**Swords to City
Centre Core
Bus Corridor Scheme**

**NTA Observations on
the Proposed Scheme
CPO Objections**

November 2023

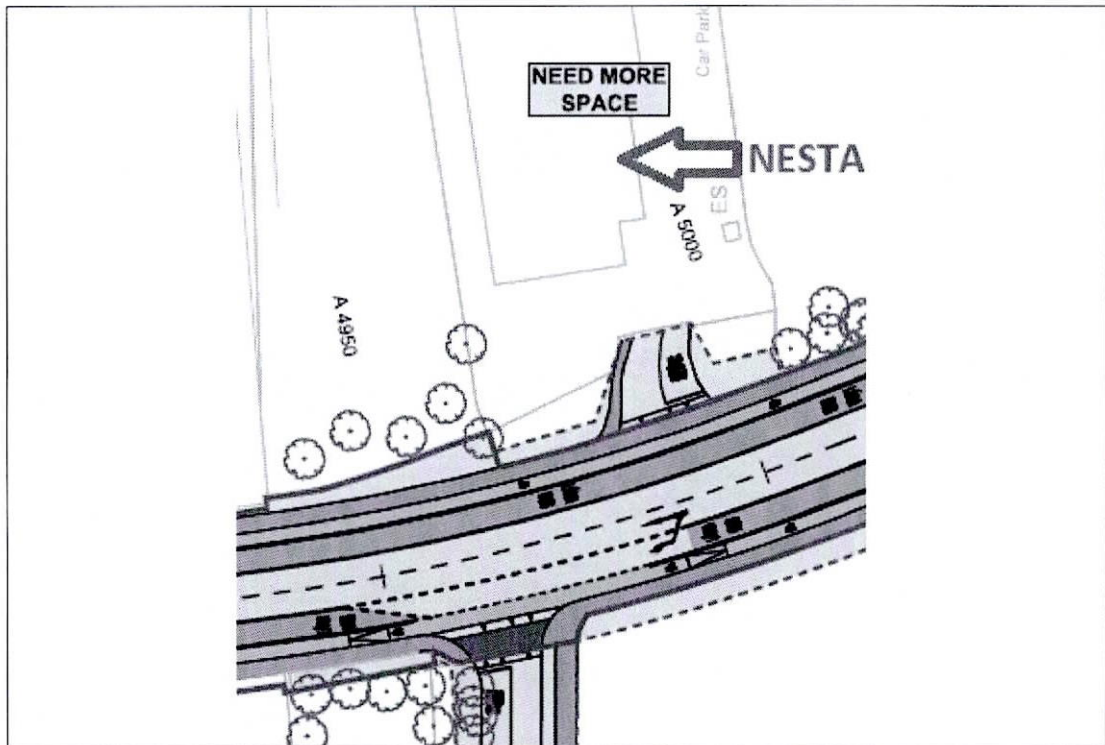
Nesta cannot be accessed from any other road and given the nature of the business (warehousing and office), any impediment to the existing vehicular access point, whether it be on a permanent or temporary basis, would be devastating to the business and would also adversely impact customers whose goods are stored on site. The nature of the business means that its operation is reliant on good quality continuous vehicular access.
